From: Amanda Scholes on behalf of Planning.Responses
Sent: 11 March 2021 09:49
To: Planning Scanning
Subject: FW: FG/18/21/PL - 10 South Drive, Ferring

I refer to the current planning application for a proposed detached dwelling to be constructed at 10 South Drive in Ferring. You will be aware that the previous application was approved for the same design, however the client has decided to now demolish the existing bungalow and to build the dwelling from new.

PROPOSED GROUND FLOOR PLAN 1:50

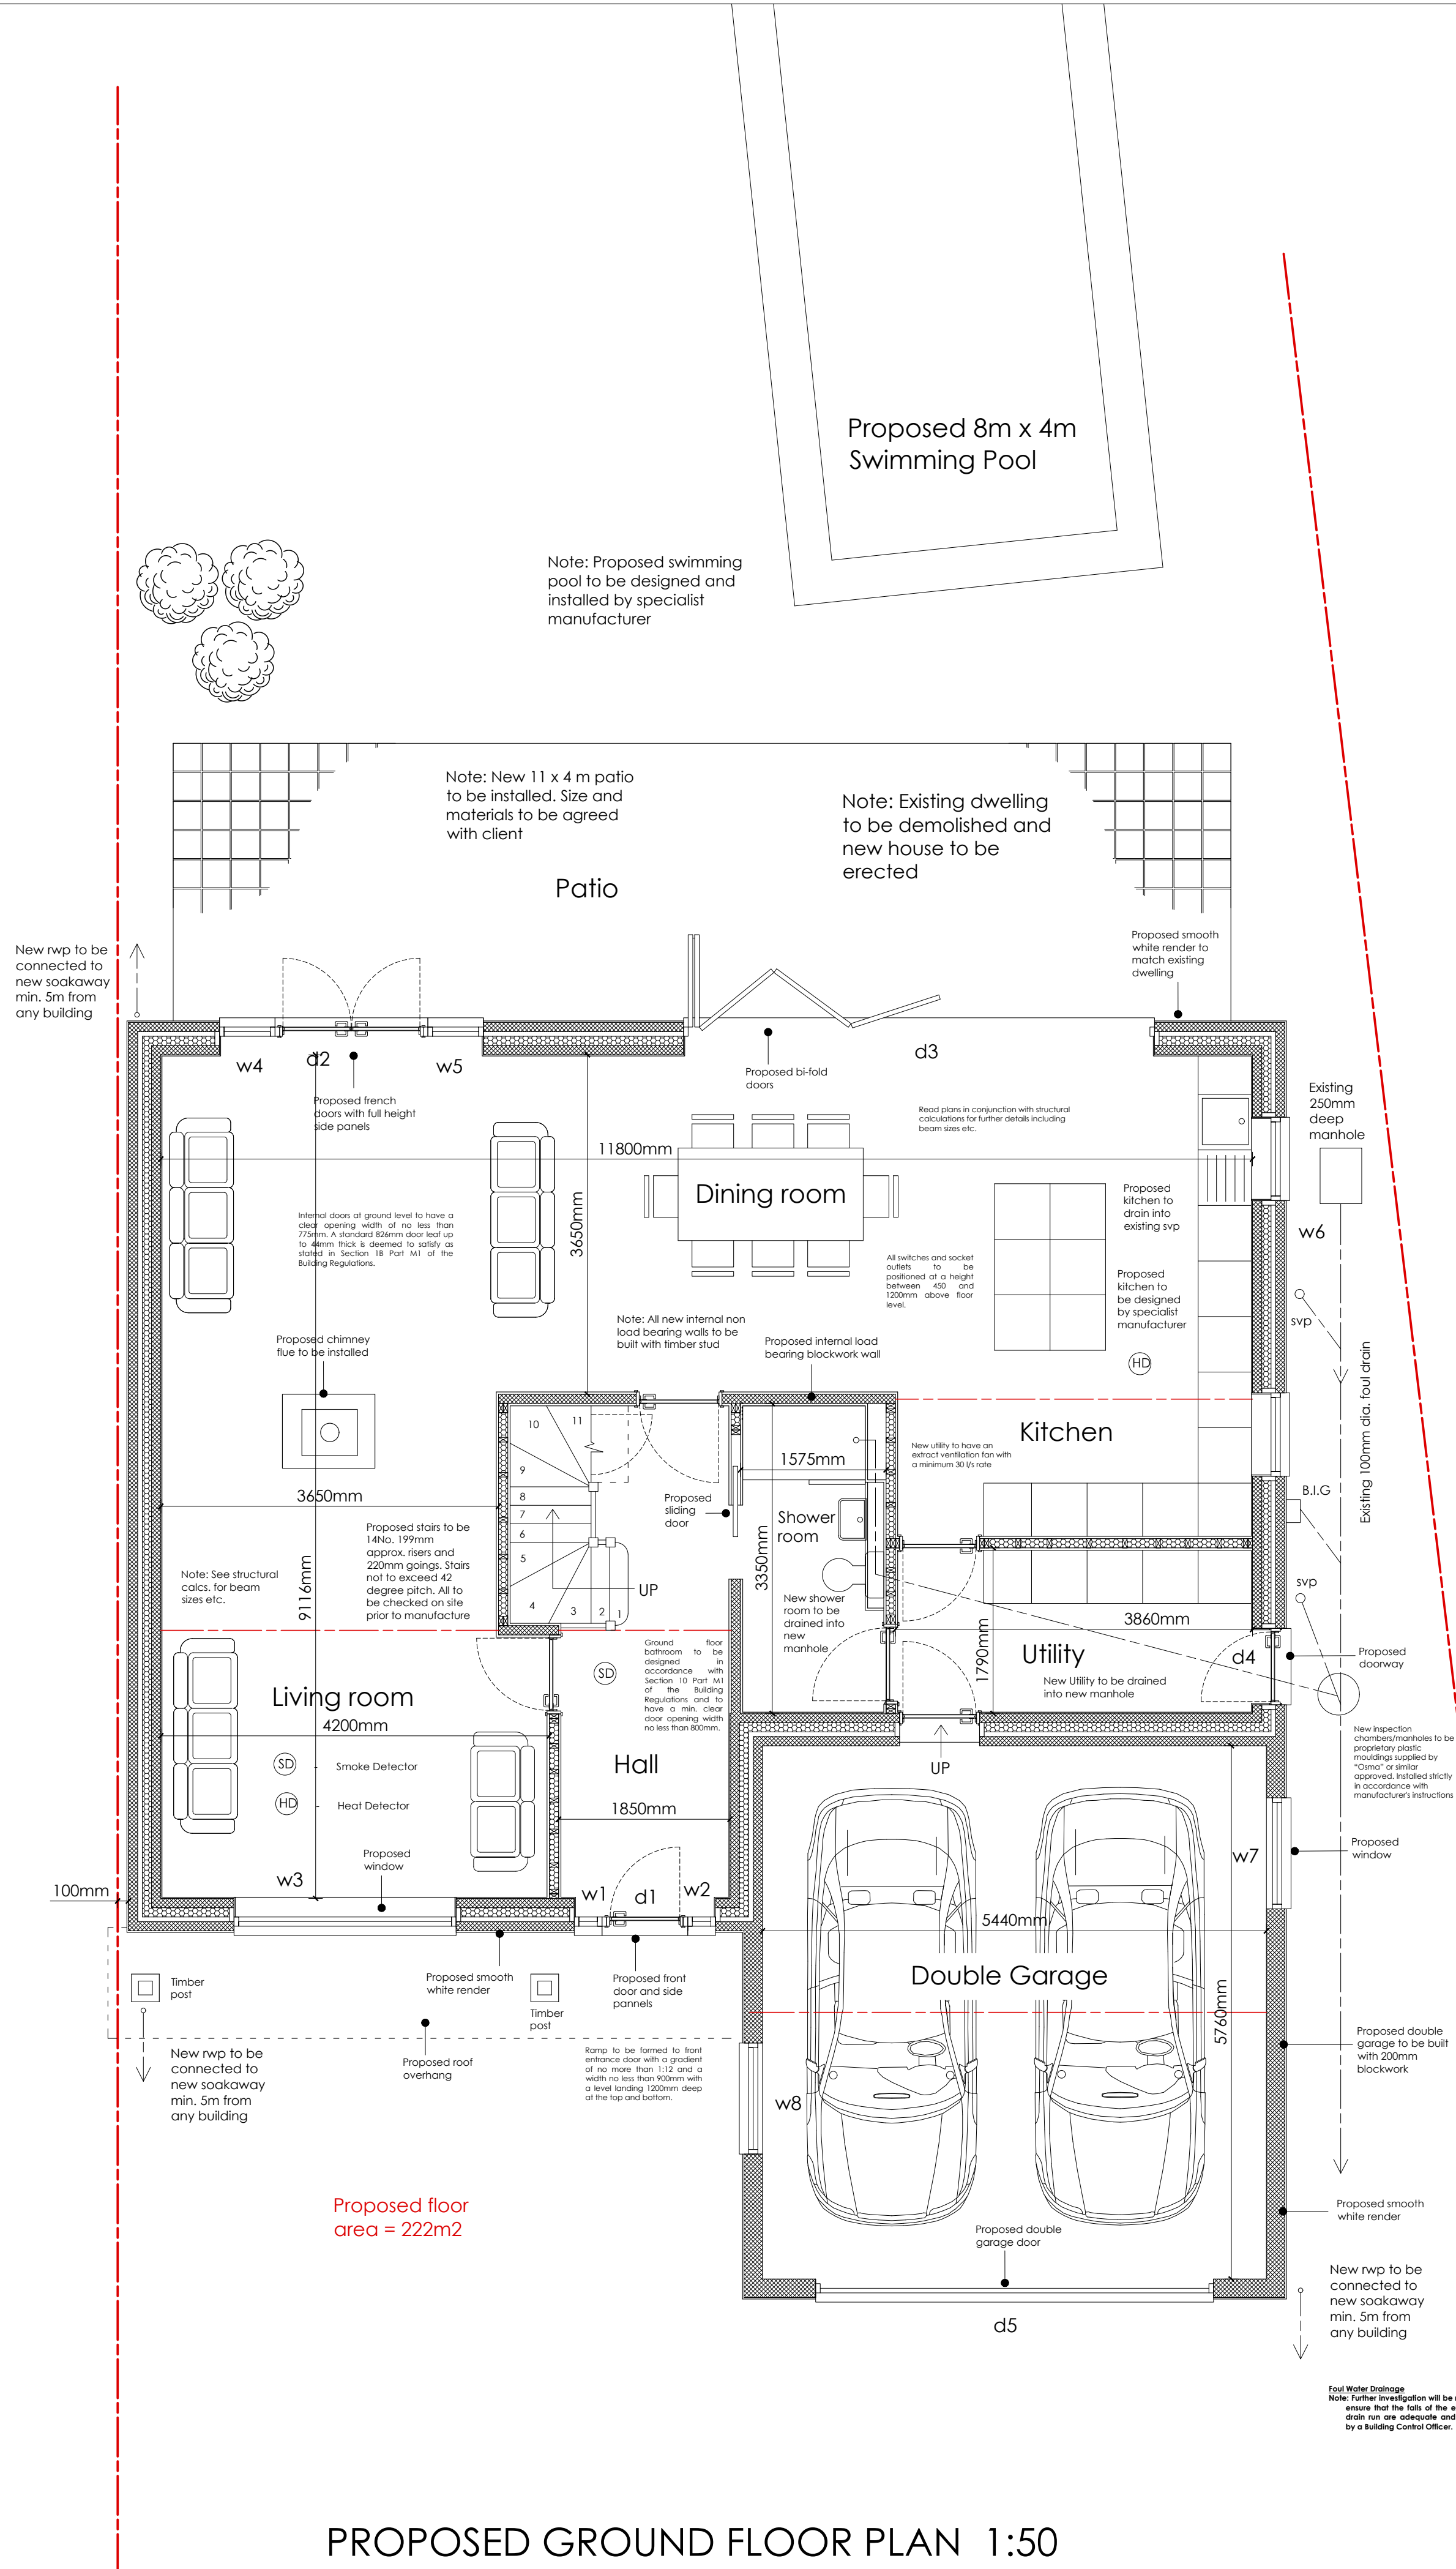
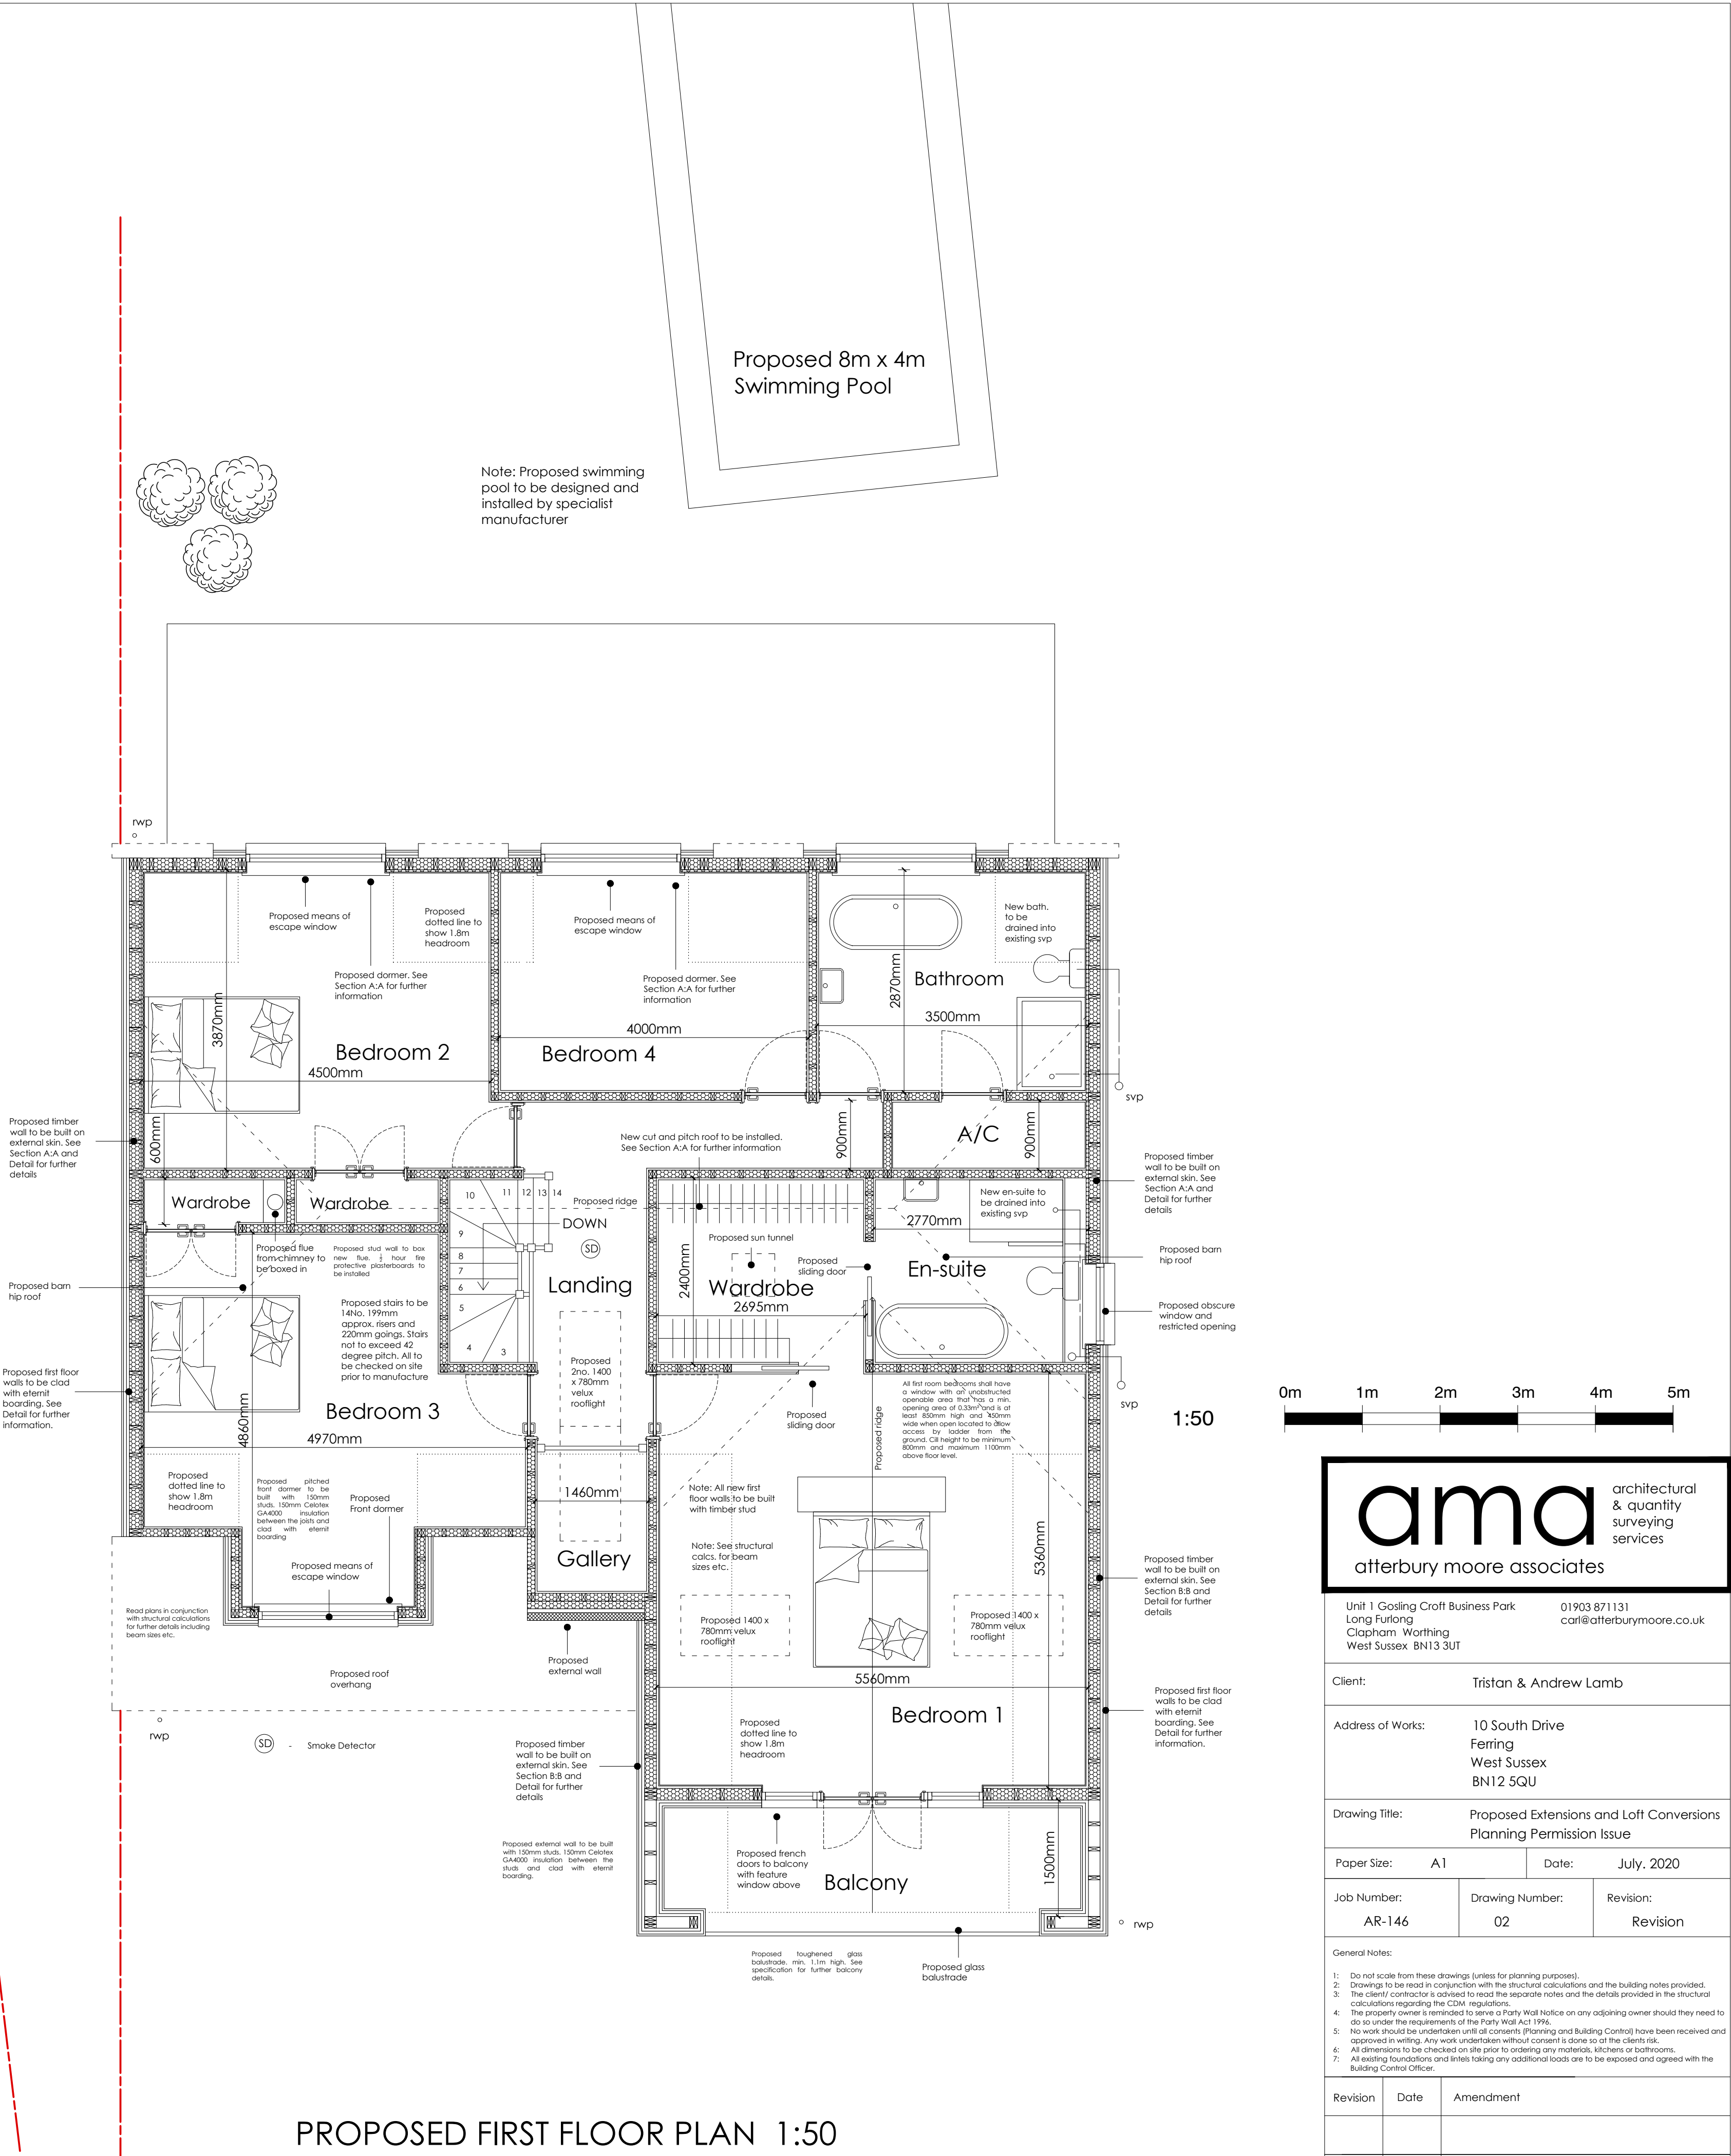
I note that the Highways Authority have advised that the double garage does not meet the current internal minimum measurements and there is no cycle storage. I can advise you that the garage is intended to be used as 1No. car parking space and the remaining part will be used for secure storage which will include space for bicycles. The existing driveway allows for at least 2 car parking spaces and therefore the proposal will include the minimum requirement of 3No. parking spaces.
